**WELWYN HATFIELD BOROUGH COUNCIL  
EXECUTIVE DIRECTOR - PLANNING, PUBLIC PROTECTION AND GOVERNANCE**

**DELEGATED APPLICATION**

**Application No:** 6/2020/3177/EM  
**Location:** 38 Brockswood Lane Welwyn Garden City AL8 7BG  
**Proposal:** Erection of a part single part double storey rear extension  
**Officer:** Mr James Homer

**Recommendation:** Refused

Scale	Date	Drawn by
1:50	10/2020	DP
Dwg. No.		Rev.
DP 1069/02

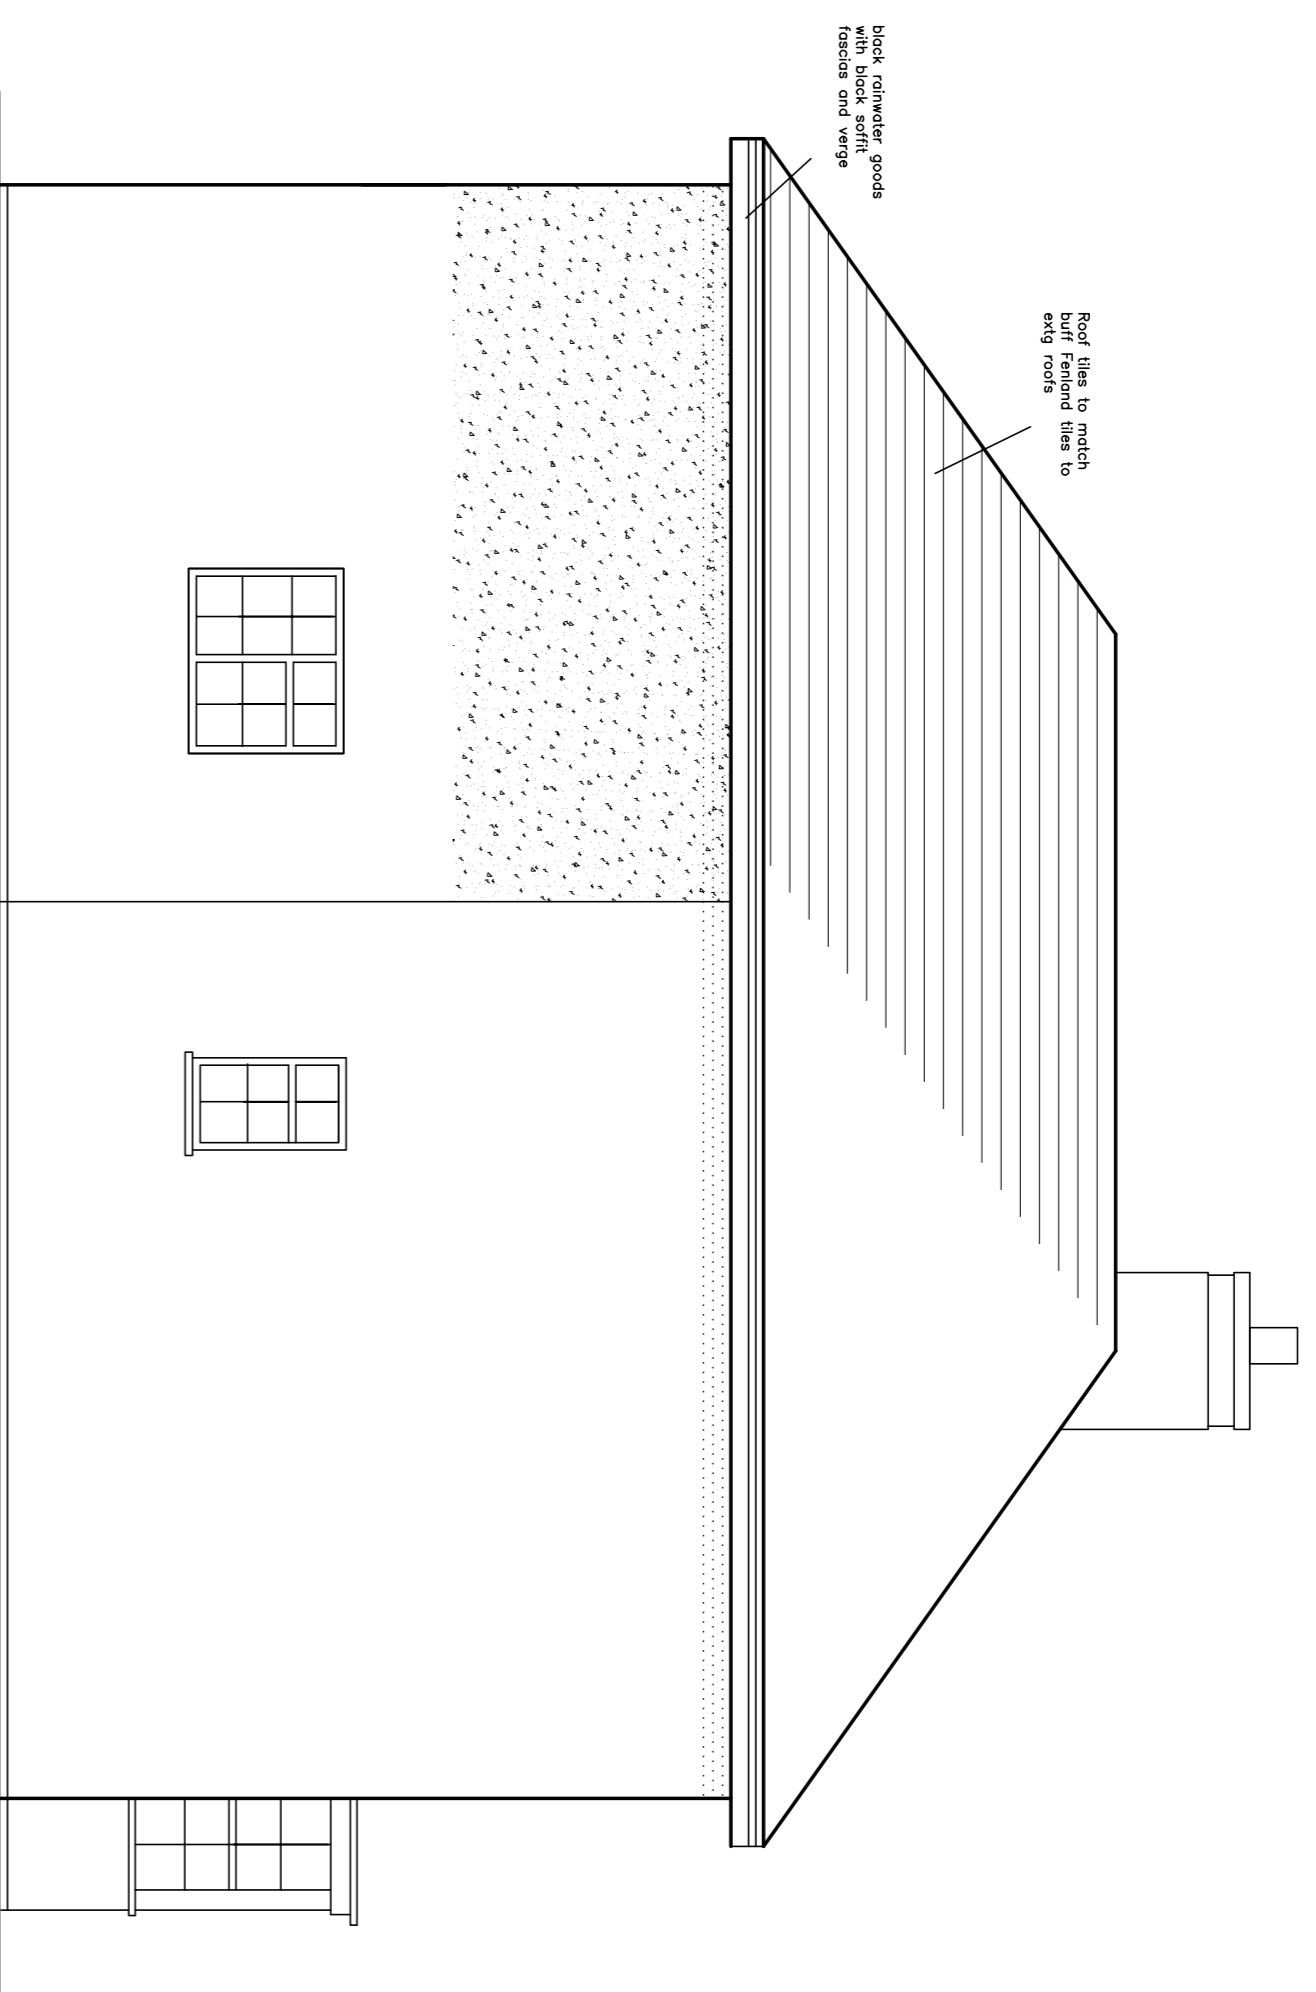
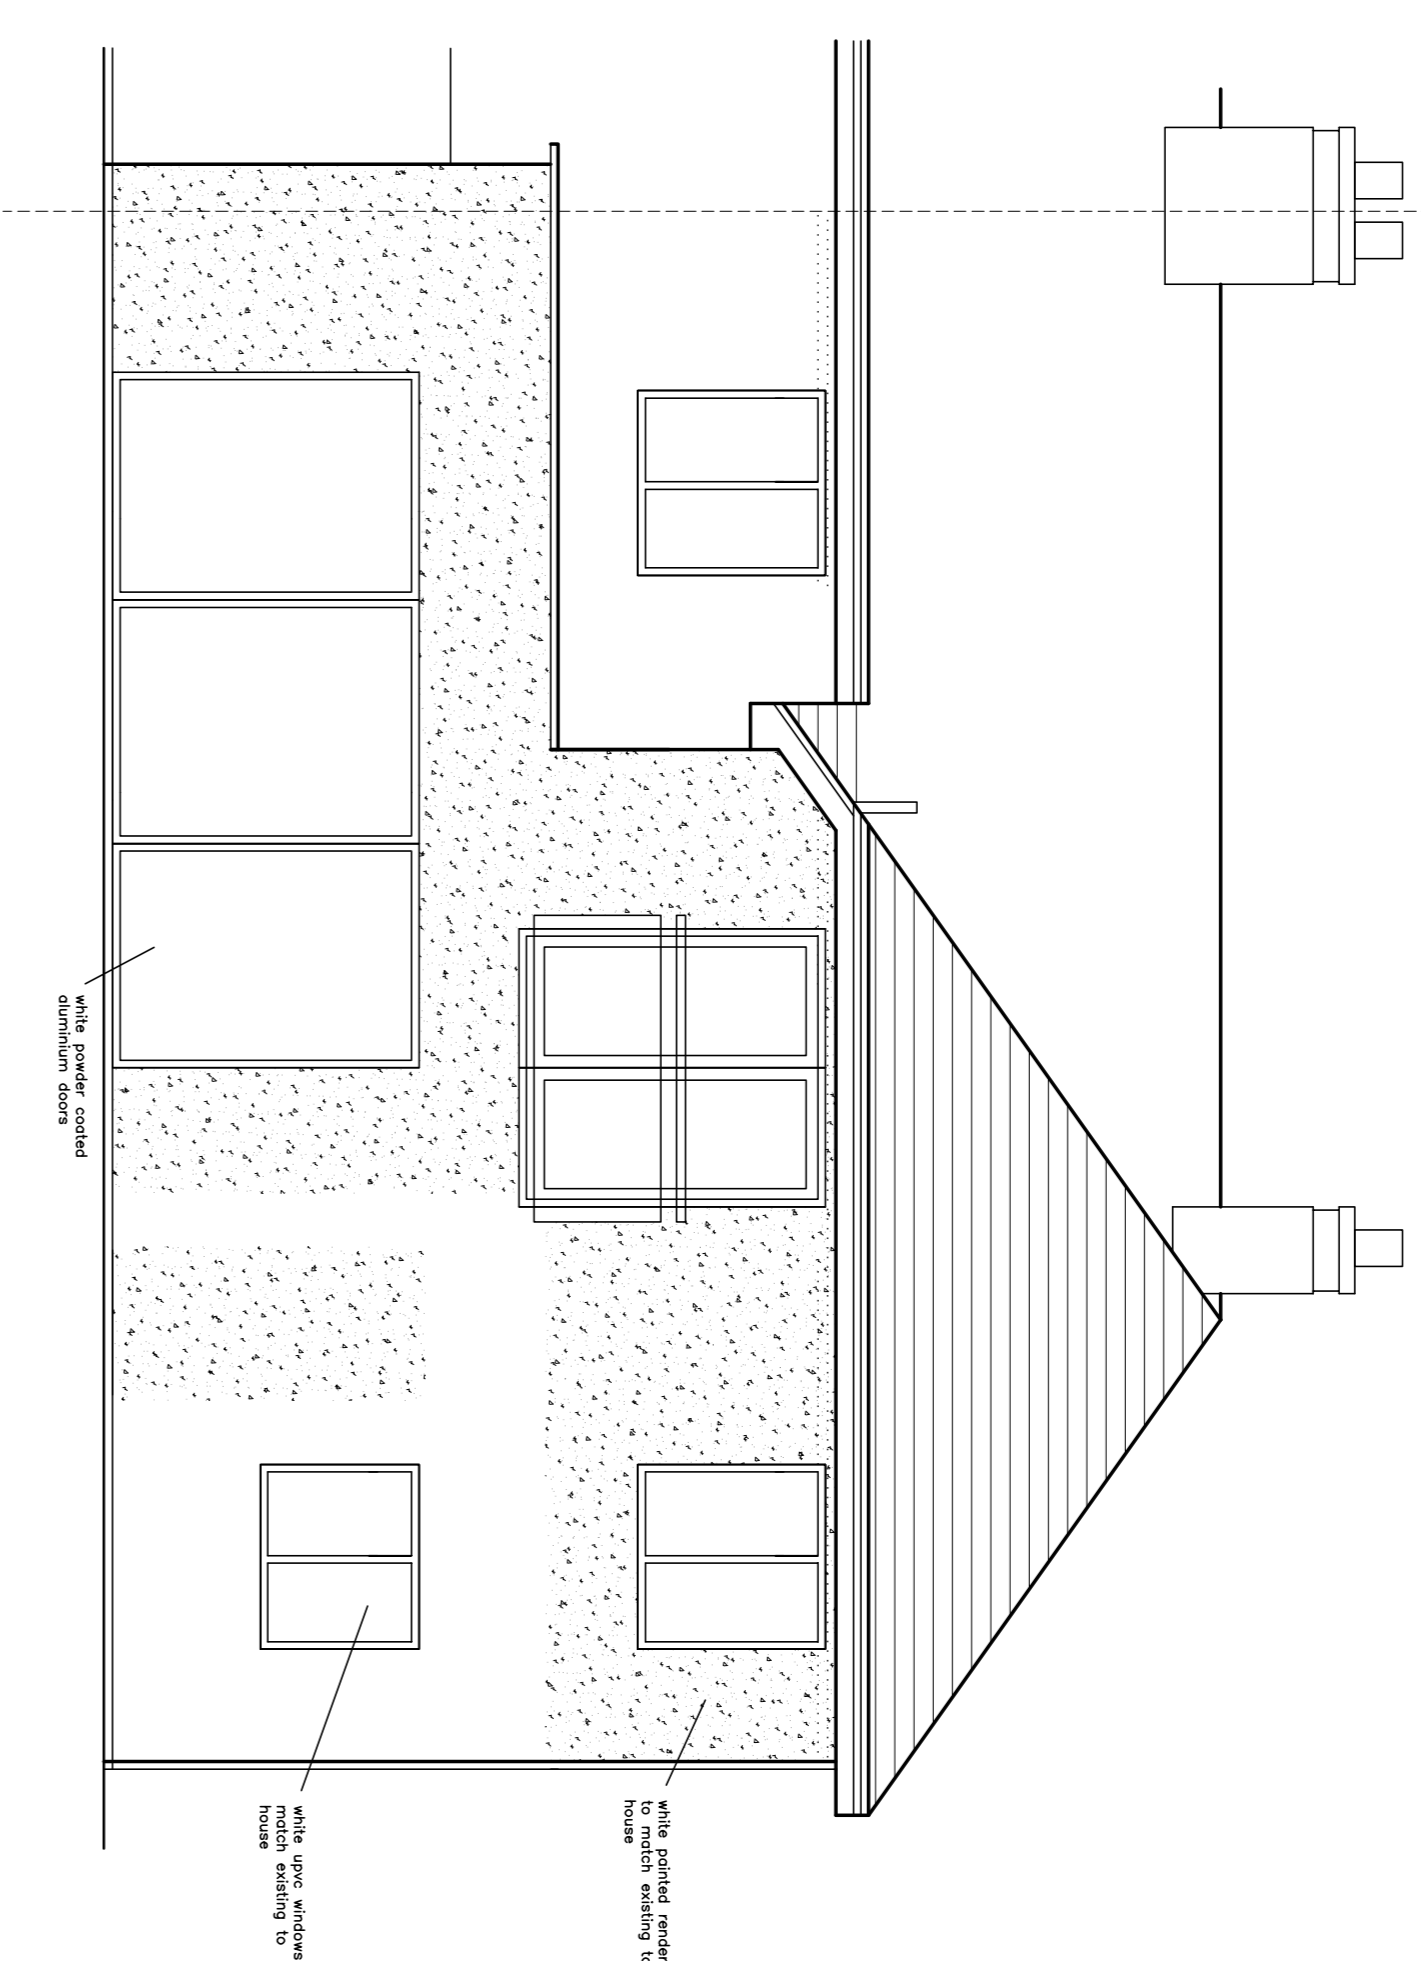
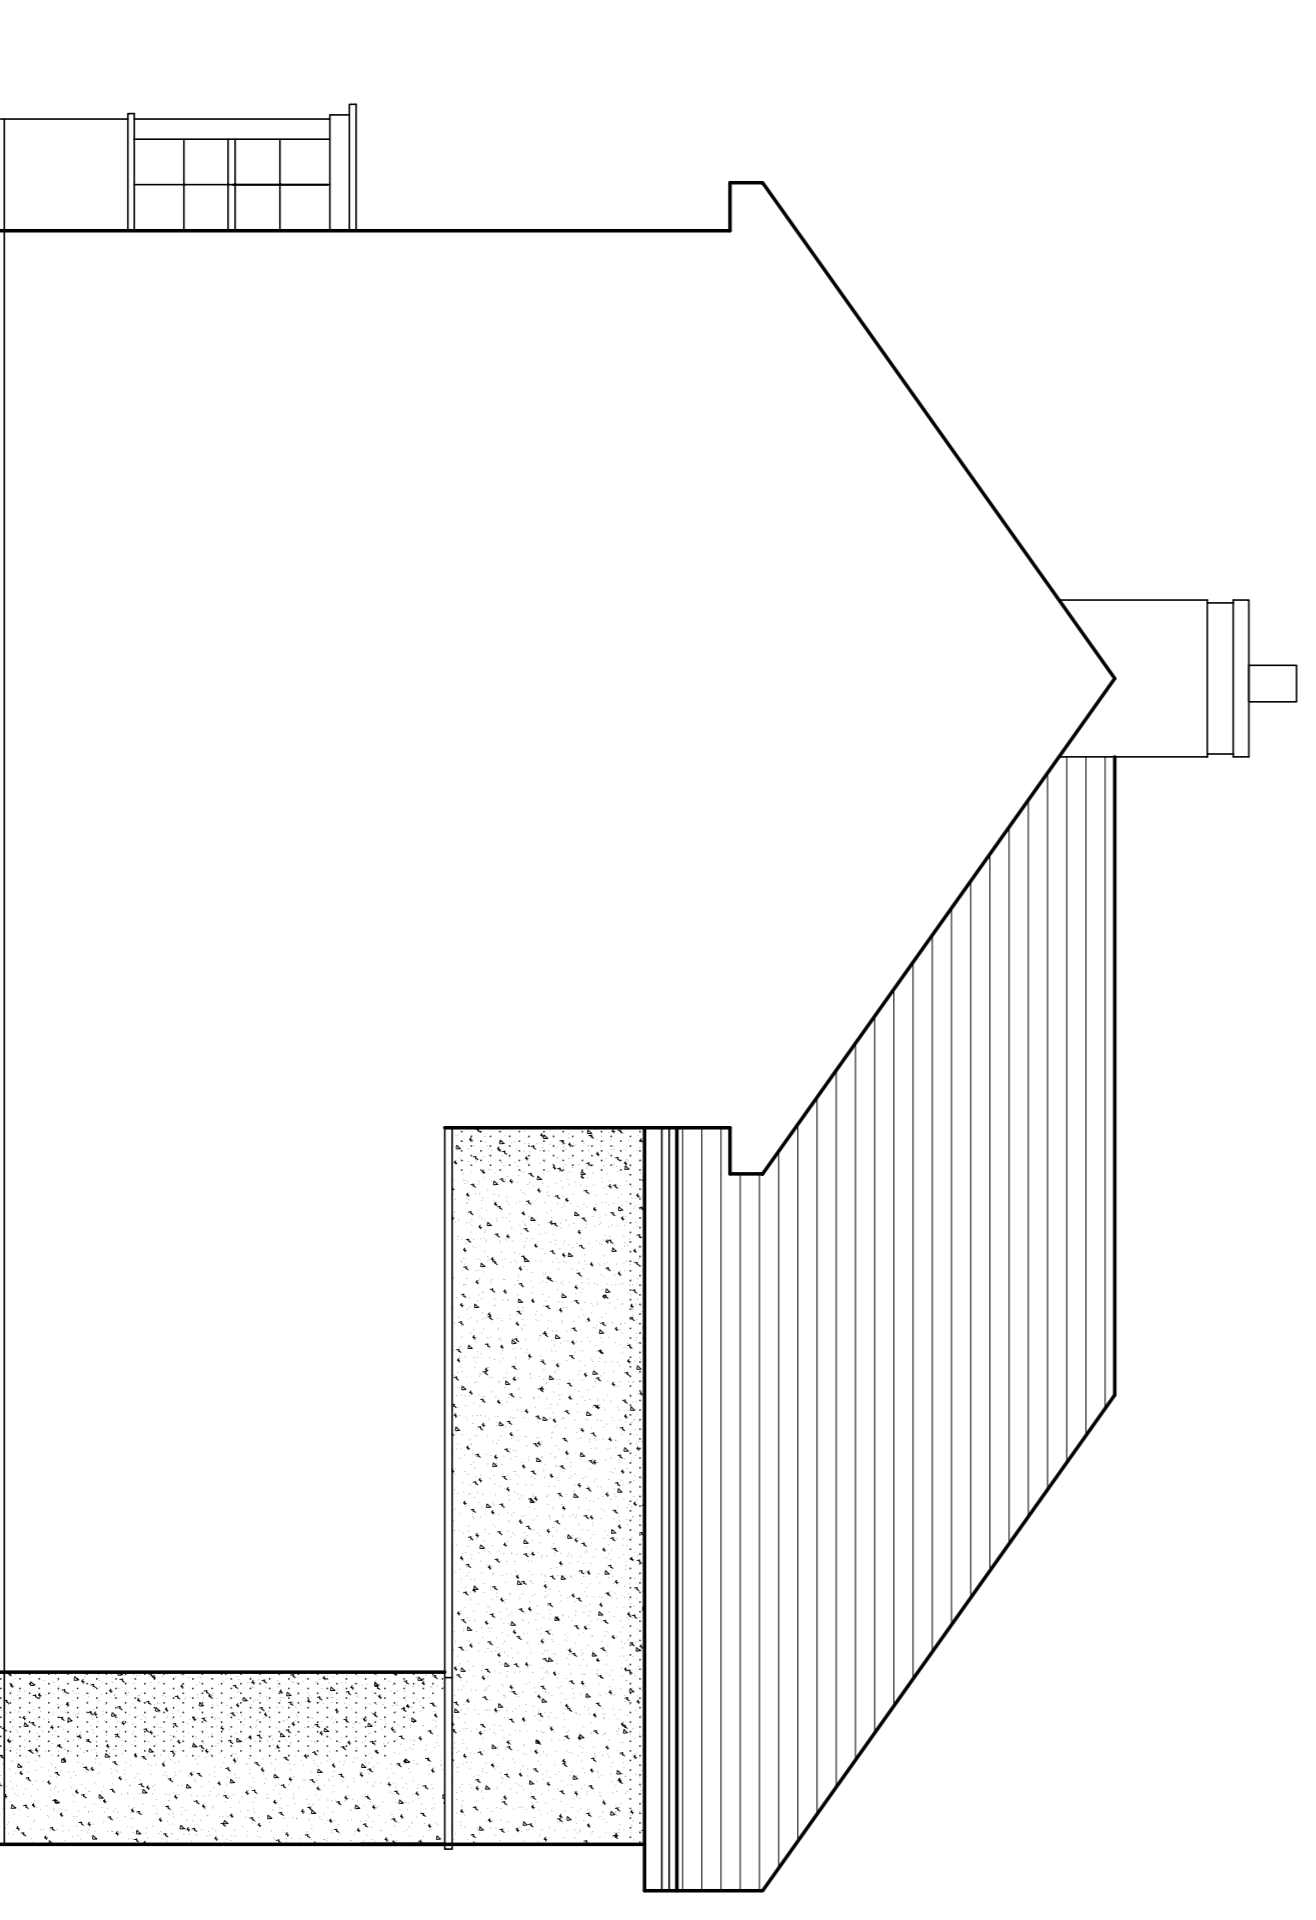
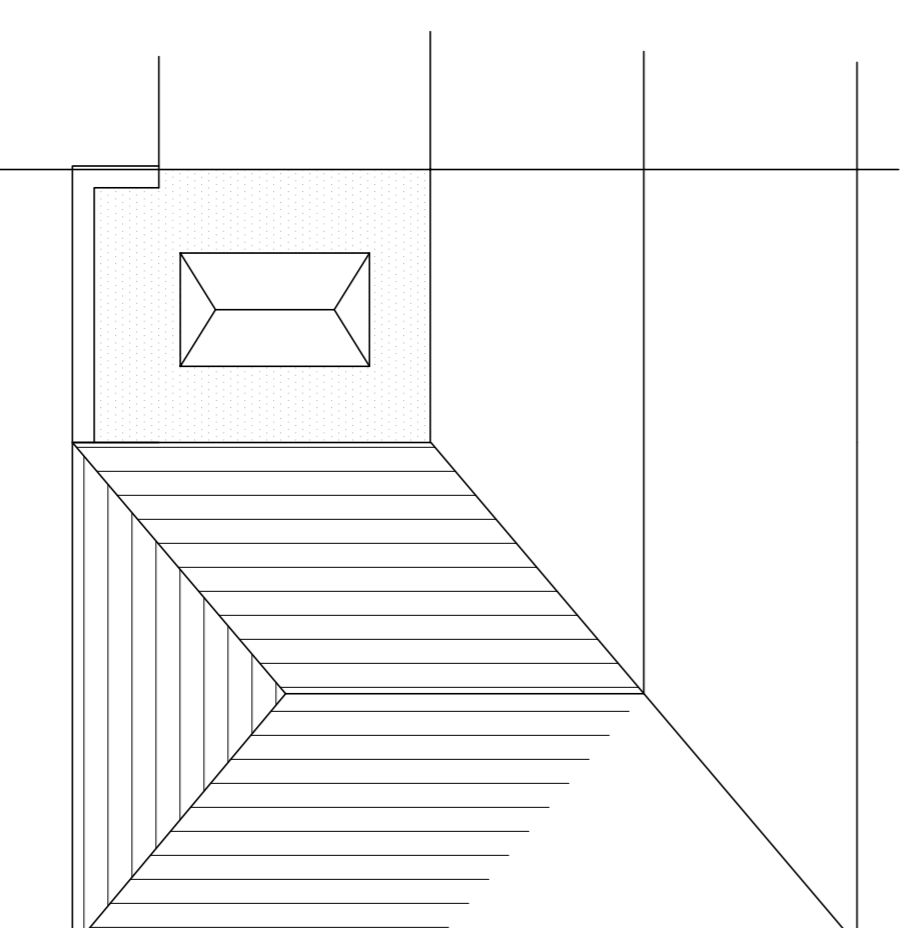
neighbouring property. It is not clear from the published plans how the single storey part of the proposed extension will affect the character and appearance of the single storey extension which is already part of the neighbouring property.
<b>Consultee responses</b>	No comments received.
<b>Relevant Policies</b>	
<input checked="" type="checkbox"/> EM1 <input type="checkbox"/> EM2 <input type="checkbox"/> EM3 Others	
<b>Considerations</b>	
<b>Design (form, size, scale, siting) and Character (impact upon amenities and values of Garden City)</b>	<p>Policy EM1 of the Estate Management Scheme states that extensions and alterations to existing properties will only be allowed if they are in keeping with the design, appearance, materials and architectural detailing used in the existing building and do not have a detrimental impact on the amenities and values of the surrounding area or the residential amenity of adjoining occupiers.</p> <p>Rear extensions should complement the character and style of the original home through the matching of materials, scale, fenestration, proportions and architectural detailing. The overall scale of a rear extension should be proportionate and adequately subordinate to the original property and should not over dominate rear gardens. Single storey extensions should have a depth no greater than 4m (where appropriate). Two storey extensions require greater levels of sensitivity to take into regard the proximity of neighbouring properties. As a result, an offset of up to 3.7m from the rear of the original building line may be acceptable, although lesser depths may be required for properties in close proximity to their neighbours. Upper floor roof pitches should be consistent with the original design of the property where the extended roof is designed to merge with the existing roof structure</p> <p>The existing conservatory is to be demolished to allow room for the proposed single storey extension. The existing single storey extension is positioned to the detached side of the building and has a depth of approx. 4.7m. This is deeper than the preferred maximum however this was approved under W6/2001/0920/EM.</p> <p>The proposed single storey extension would be adjoined to the eastern side of the existing extension at a depth of 4.7m and would extend across the full width of the property in place of the demolished conservatory. Adjacent to the shared boundary with 36 Boundary Lane the proposed extension would be approx. 3m in height and higher than the existing conservatory. At 4.7m in depth across the full width of the house and 3m in height, the proposed extension is not considered proportionate or adequately subordinate to the original home.</p> <p>The first floor element of the proposed extension would be positioned above the existing section of the ground floor extension with a depth of 4.7m and approx. width of 6.7m. The proposed extension features a hipped roof which, although matches the pitches of the existing roof, it set at the same height. The roof drops lower than the existing roof on the eastern side of the extension to accommodate the width proposed. The height of the proposed roof does not establish a subordinate relationship to the main building and the depth of 4.7m contributes further to the disproportionality.</p>

additional height and solid structure of the extension is likely to overbearing. The concern raised by no.36 regarding the shared wall is outside of EM consideration, however, the applicant would only be able to undertake work within the boundary of their property. Any work to tie in the extension on the neighbour's side would require their consent.
<b>Landscaping issues (incl. hardstandings)</b>	None.
<b>Any other considerations</b>	None.
<b>Conclusion</b>	
The proposed extension is considered too deep, and will result in an addition that would not be proportionate or adequately subordinate to the original house. This would be exacerbate as the roof has not been stepped down to appear subservient to the main building. In addition the proposed extension would introduce an overbearing addition upon the shared neighbour boundary with no.36. Accordingly, the application fails to comply with Policy EM1 of the Estate Management Scheme.

1. The proposed extension is considered too deep, and will result in an addition that would not be proportionate or adequately subordinate to the original house. This would be exacerbate as the roof has not been stepped down to appear subservient to the main building. In addition the proposed extension would introduce an overbearing addition upon the shared neighbour boundary with no.36. Accordingly, the application fails to comply with Policy EM1 of the Estate Management Scheme.
